RESPONSE TO SUBMISSIONS – SSD-80814238

ROAD 1 DATA CENTRE, 1-5 KHARTOUM ROAD, MACQUARIE PARK

**B99 VEHICLE SWEEP PATHS**

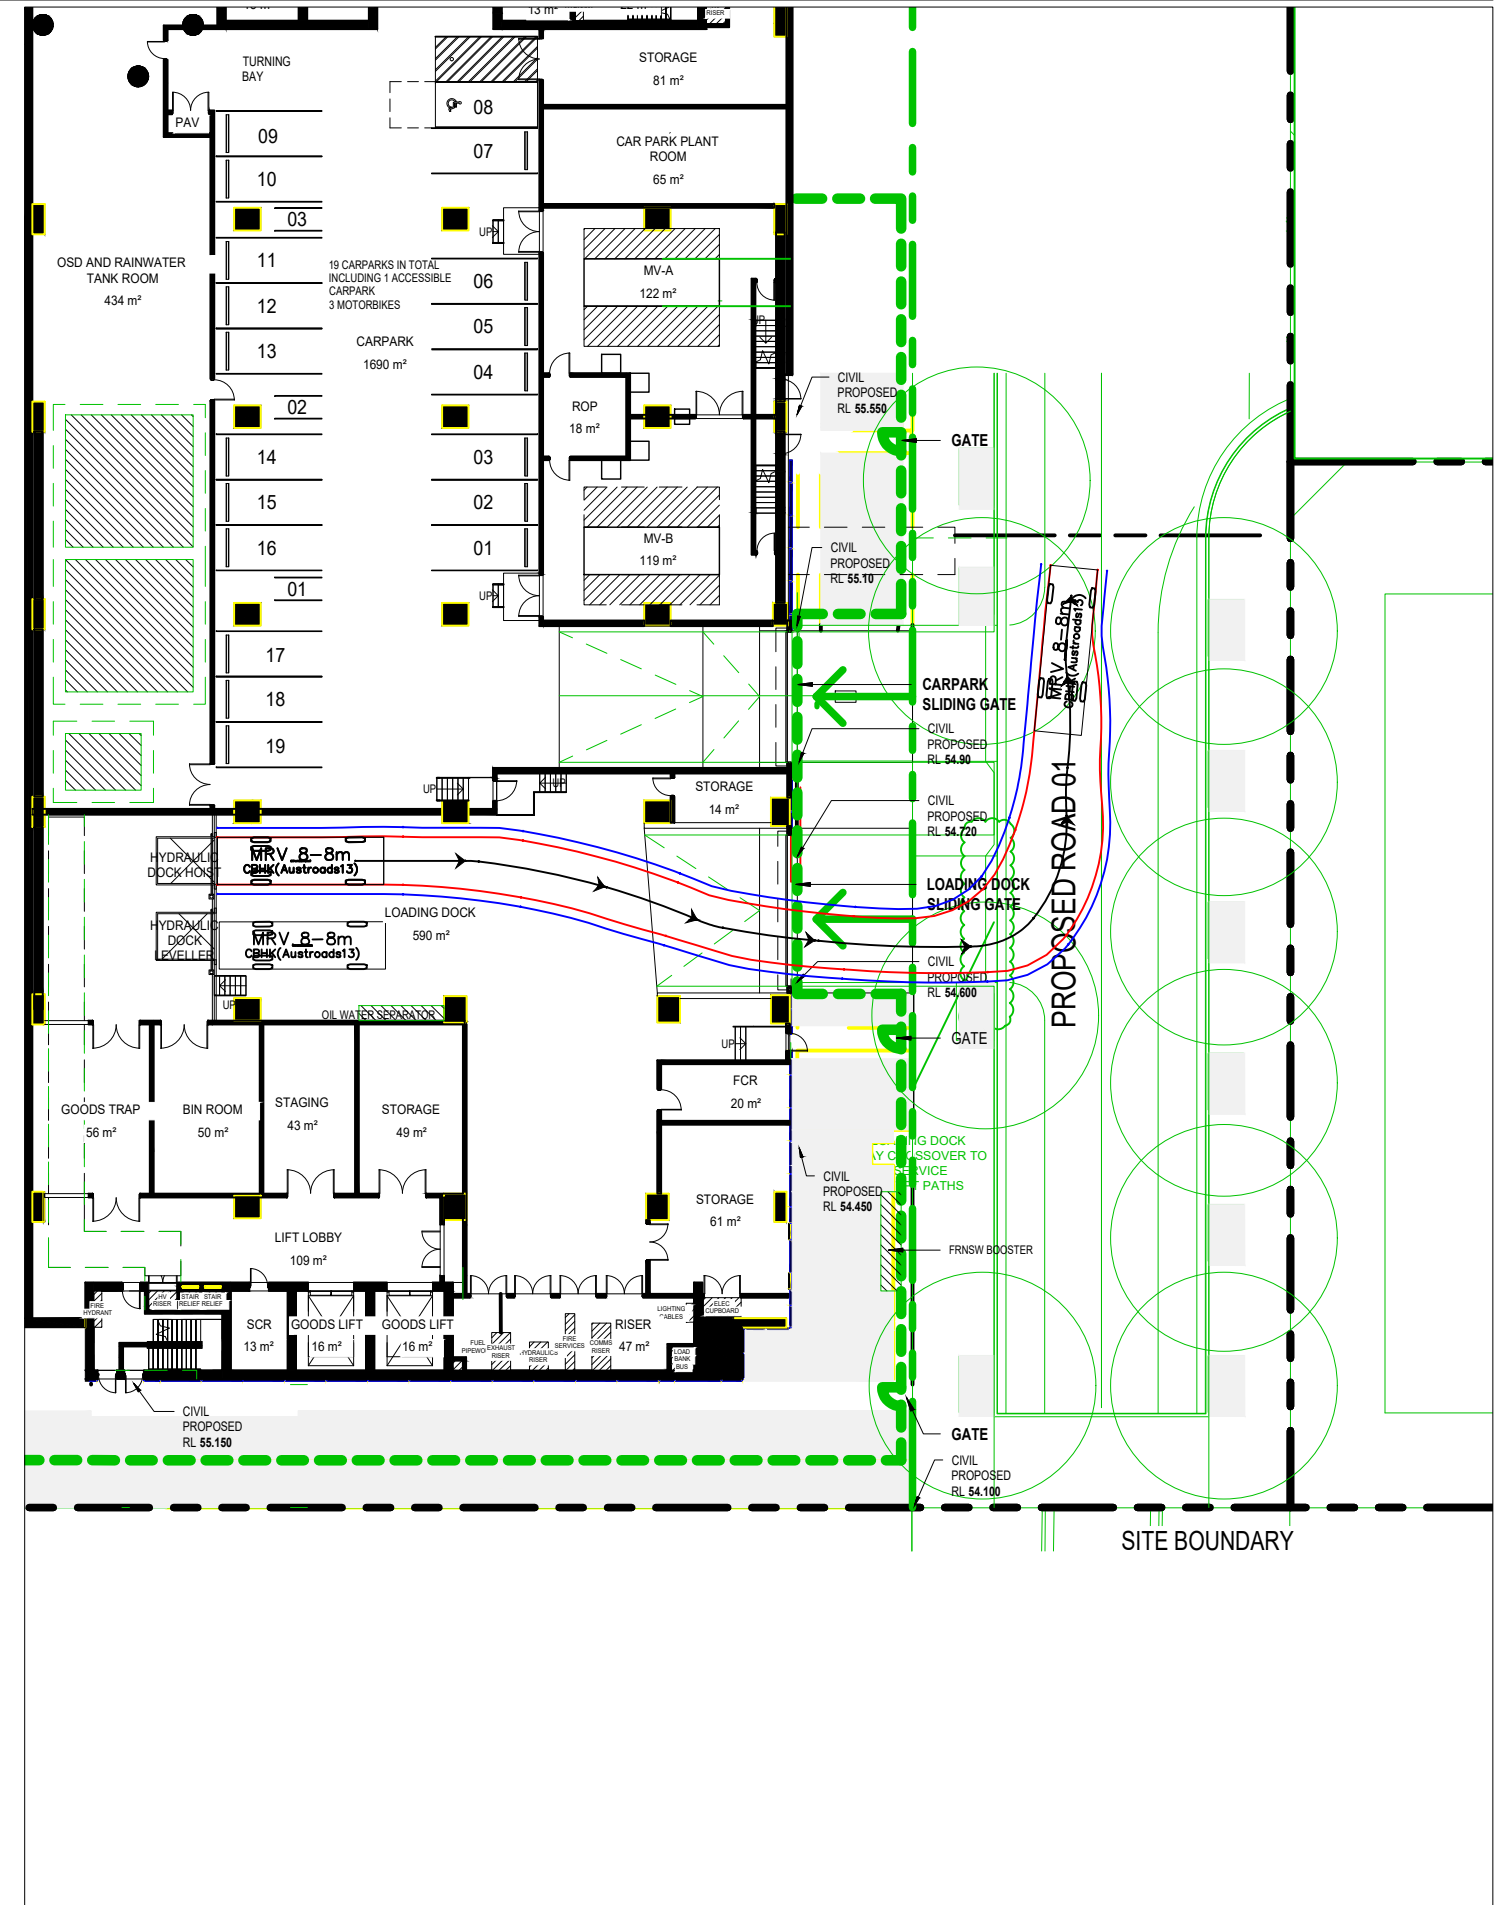
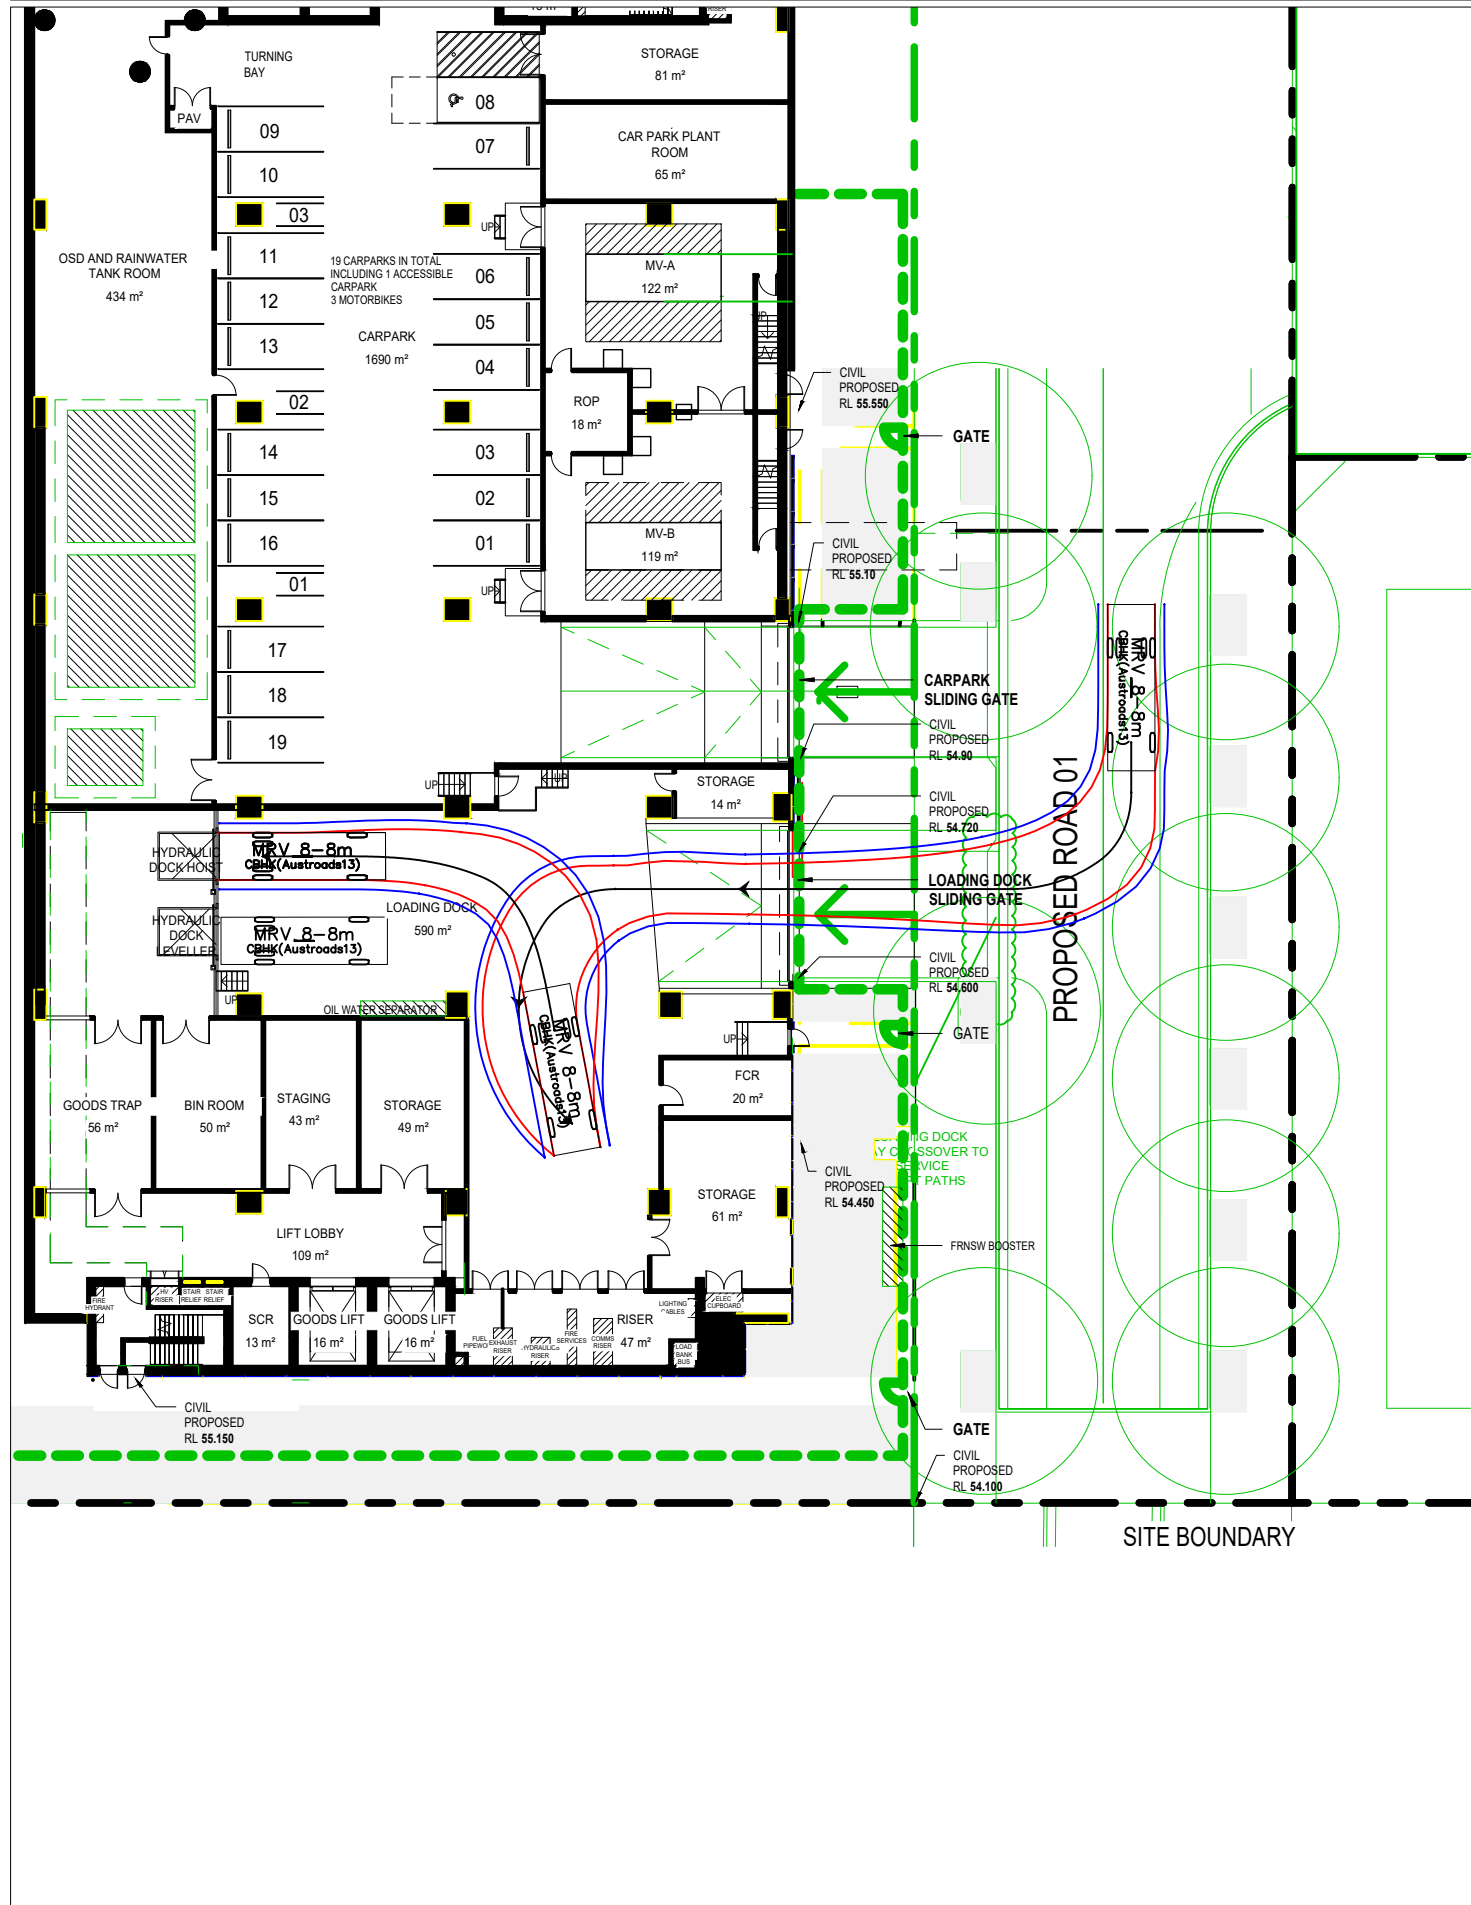
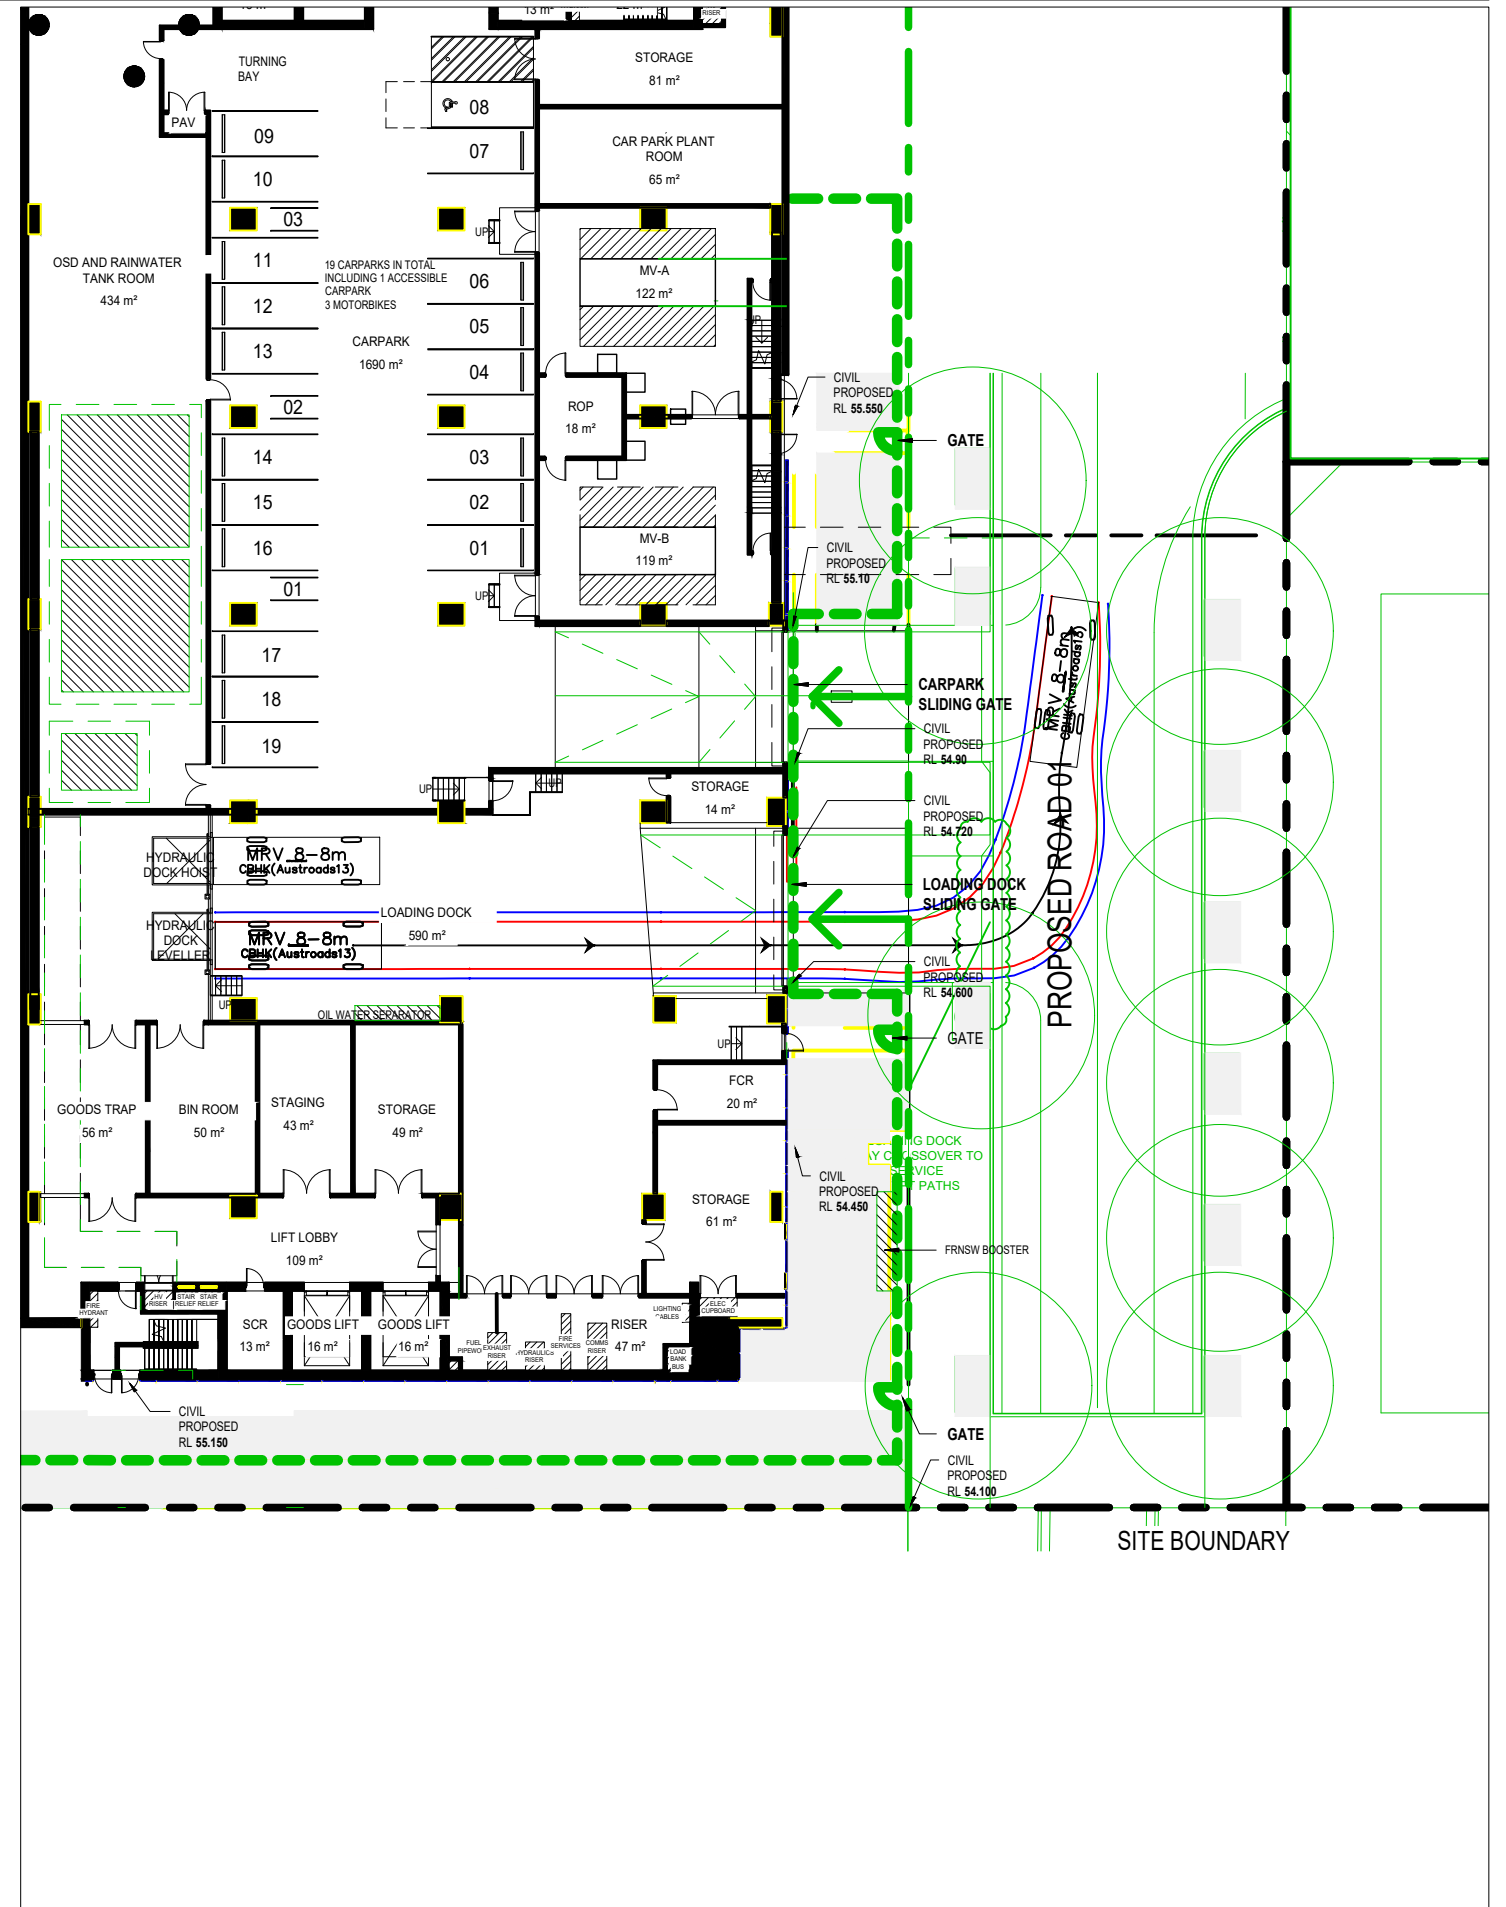
<p><u>Traffic and Parking</u></p> <p>Clarification is required as to why this proposed data centre does not require 19m/20m long trucks, which are typically proposed for each of other data centres in Macquarie Park. This clarification is requested to address potential future challenges related to operating 19m/20m long trucks at the site.</p> <p>It is requested that an estimate of truck trips be provided based on the site's operational and maintenance requirements and assess their impact on the local road network. Specify the largest truck size and include swept path analyses for inbound and outbound movements at the intersections of Talavera Rd/Road 22, Road 22/Road 1, ensuring a MRV can safely pass a B99 car, and at the site access driveway.</p>	<p>The proposed development comprises a data centre with four floors of technical data floor space (accommodating eight data houses) with a data hall GFA of approximately 6,572sqm. It is substantially smaller in scale compared to other neighbouring data centres in Macquarie Park. For this reason, the operational servicing requirements differ, and the data centre use does not necessitate regular 19m/20m truck movements.</p> <p>Day-to-day servicing will be undertaken by small to medium rigid vehicles up to 8.8m in length. The loading dock access driveway and on-site manoeuvring areas have been designed to ensure these service vehicles can enter and exit the site in a forward direction and without the need to queue or dwell on the adjacent road network. Based on the nature of the use, the proposed data centre is expected to generate low service vehicle volumes, typically two to three vehicle trips per day.</p>	Attachment C

Summary of Issue Raised	Response	Supporting Document
	<p>General maintenance activities, including delivery or replacement of diesel generators, will be very rare and infrequent. These activities may require large rigid trucks or 19m articulated vehicles. When such works are required, deliveries will occur under traffic management control, with a mobile crane positioned within the kerbside and northbound traffic lanes of Road 1 across the loading dock and car park access driveways. The crane will lift generators directly into the generator racking area within the building. These works will be subject to a standard application to City of Ryde and supported by a detailed traffic management plan.</p> <p>Regarding intersection performance, the Talavera Road and Road 22 intersection was designed and constructed as part of the completed data centre at 8 Murrell Street, Macquarie Park. Council approved this intersection on 16 May 2022 in conjunction with the endorsed design for Road 22. Swept path analyses for an MRV, B99 car, and relevant design vehicles at Talavera Road/Road 22, Road 22/Road 1, and the site driveway have been prepared and are included in Attachment C.</p>
